Office of
Environment
& Heritage

DOC17/318643
SSD 8126

Redevelopment of the UNSW Cliffbrook Campus, 45-51 Beach Street, Coogee (SSD 8126)

ATTACHMENT 1: Office of Environment and Heritage (OEH) comments for the Redevelopment of the UNSW Cliffbrook Campus, 45-51 Beach Street, Coogee (SSD 8126)

Figure_A 7 – Pre Developed – Peak Hazard Classification – 1% AEP

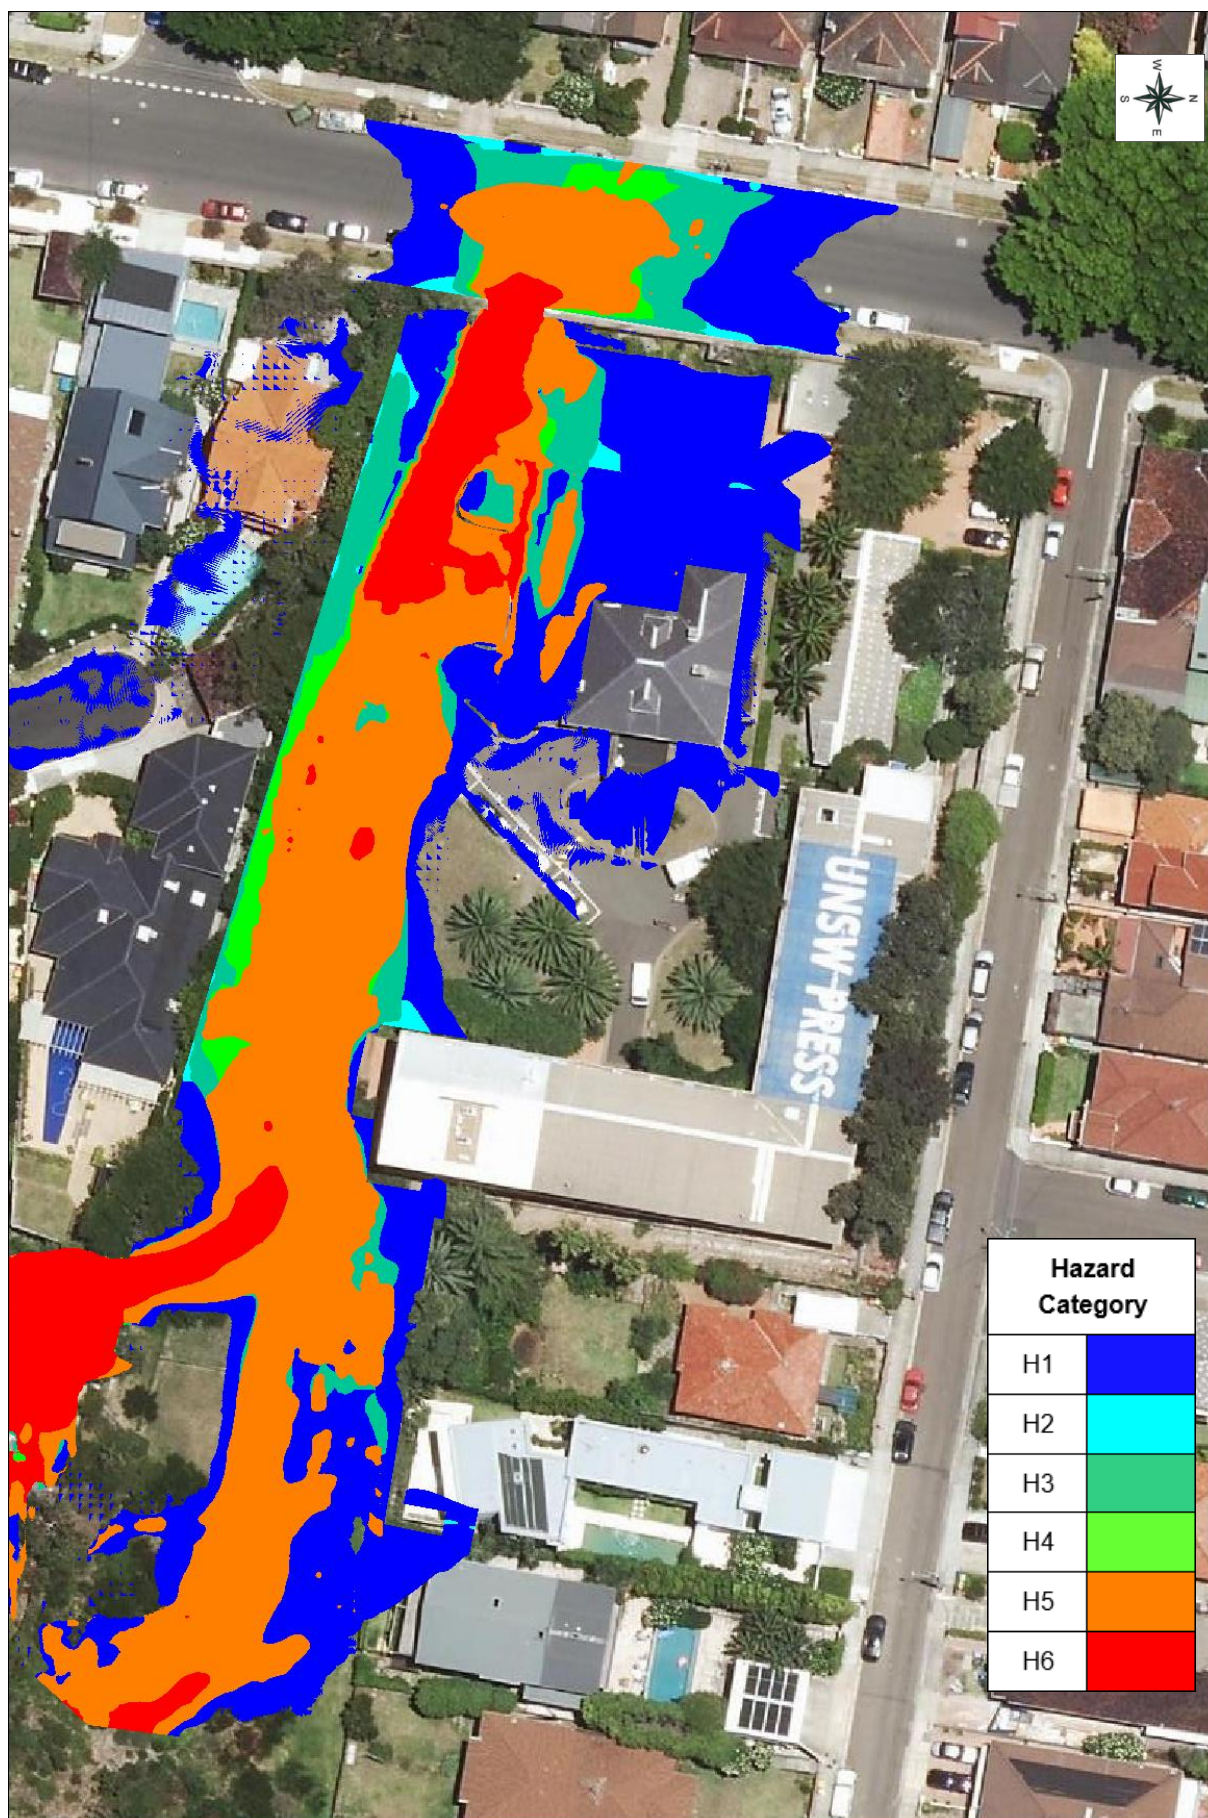
The proposed floor levels of the basement car park and the Lower Ground floor of the Eastern Entrance have a freeboard allowance 0.15 m and 0.075 m above the 1% AEP respectively. Item (f) of the recommended actions, suggests greater freeboard for the lower ground floor or alternatively the south-eastern entrances to the lower ground floor be sealed off and designed to include flood proof doors for a minimum height of 0.5 m. OEH acknowledges this recommendation but highlights that it is prudent to achieve a minimum freeboard of 0.5 m for the lower ground floor level similarly at the entrance of the basement carpark.
